Re: Smeaton Grange SSD 7424 Modification 1 Amendment - Condition B61

This letter is to request the Department's consideration of an amendment to the SSD 7424 Modification 1 application (modification), currently being considered by the Department. The proposed amendment concerns Condition B61, which relates to the design and construction of the site security fencing at the front of the development, and Camden Council's (Council) role in approving the design.

FRONT FENCE DETAIL PLAN  
SCALE 1:200

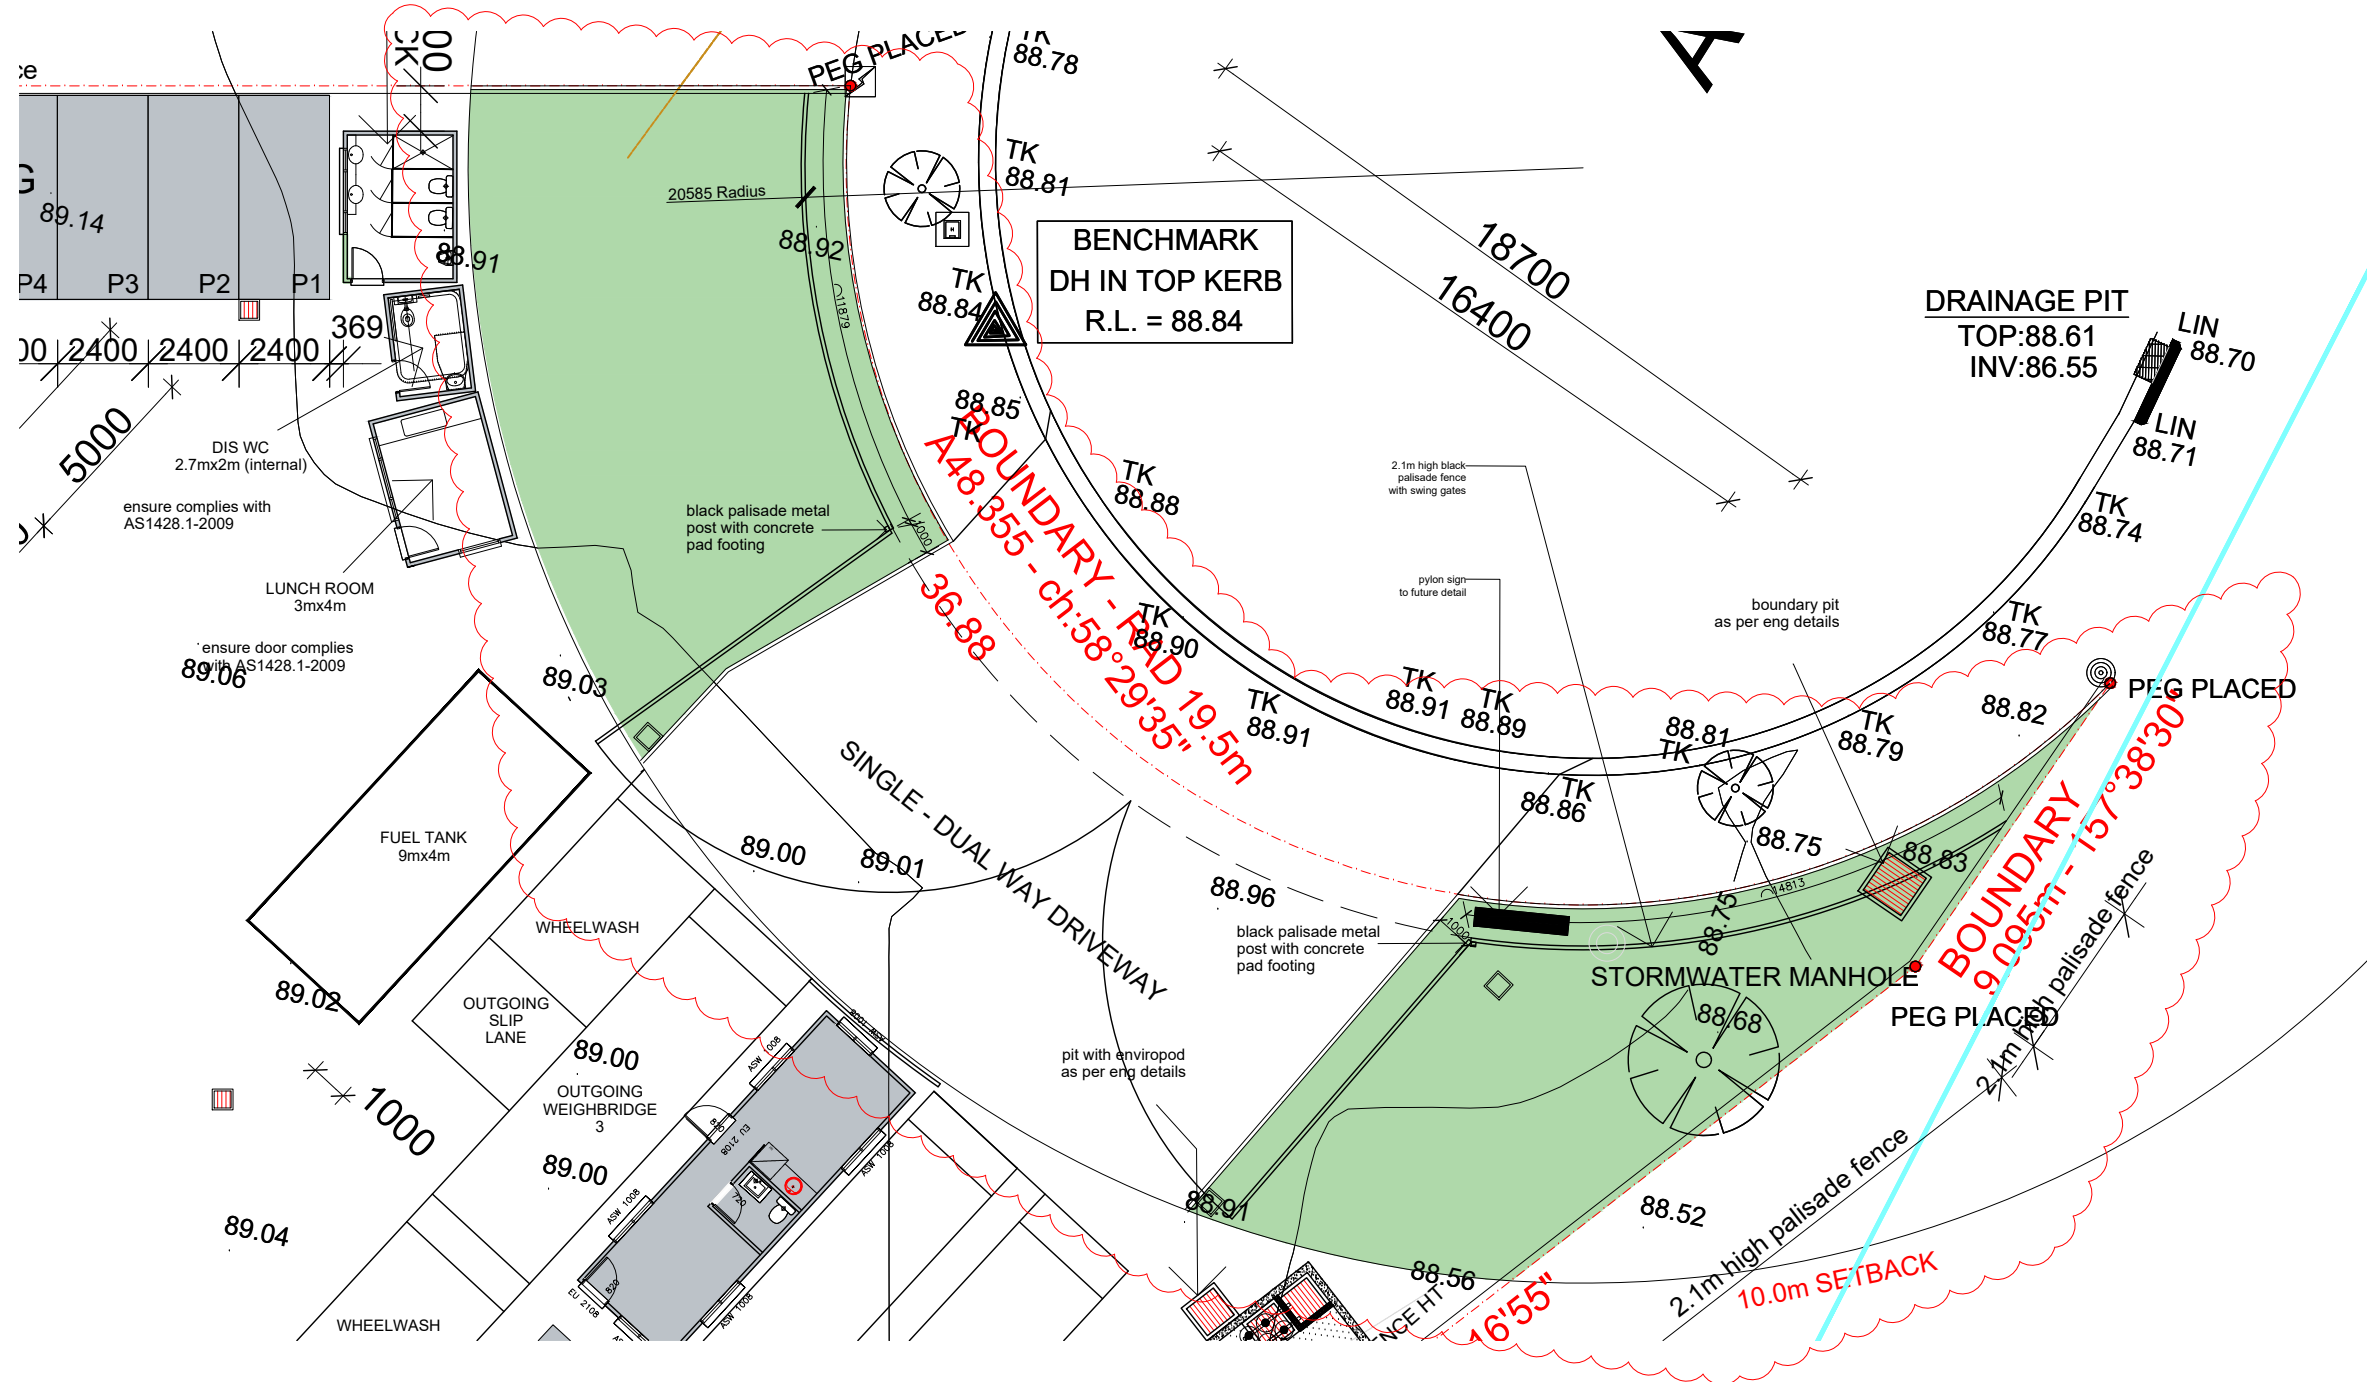
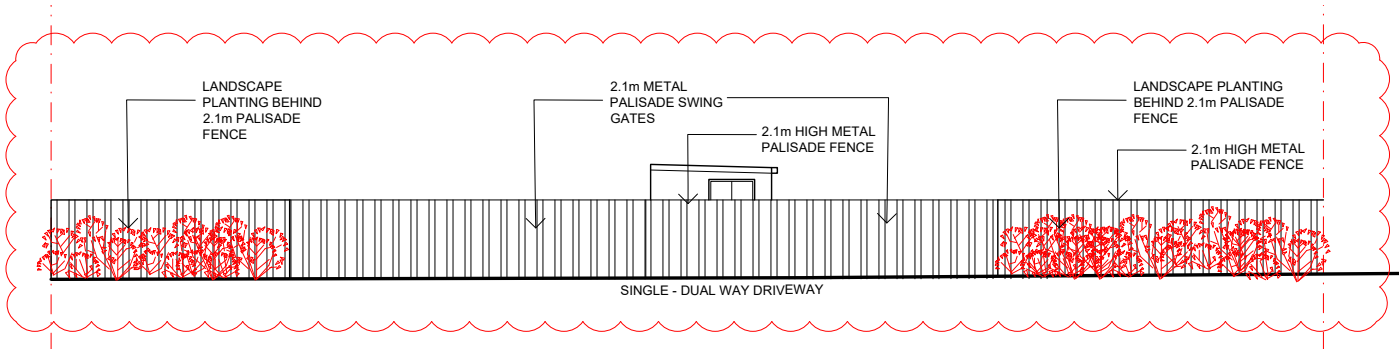
The relevant sections of *Camden Council Development Control Plan 2011* (DCP) relating to the security gates and fencing at the front of the site is D4.2.5 Fencing. The proposed design, a 2.1 m tall black palisade fence, setback 1 m from the site:

- Is 'safer by design' (eg taking public safety into account when designing public space) for the reasons described in the modification's Statement of Environmental Effects (SEE) Section 3.5;
- meets the DCP's maximum height of 2.1 m;
- is a type of 'decorative metal' fence;
- meets the DCP's 1 m minimum setback;
- is able to allow for the flow of overland flood flow paths due to high permeability; and
- is designed with gates behind the landscape area which swing into the property.

As explained above, the fence meets the requirements of the DCP. Therefore, requiring the detail design of the fence design to be approved by Council has no practical benefit. If the condition must be retained, consulting with Council regarding the design would allow Council to comment on any areas of concern. Concerns would then be addressed as per the Evidence of Consultation requirements (Condition A13), to be considered by the certifying authority.

We request that the condition be removed, or amended to:

The site security gates and fencing at the front of the site are to be designed in consultation with Council prior to the commencement of construction.
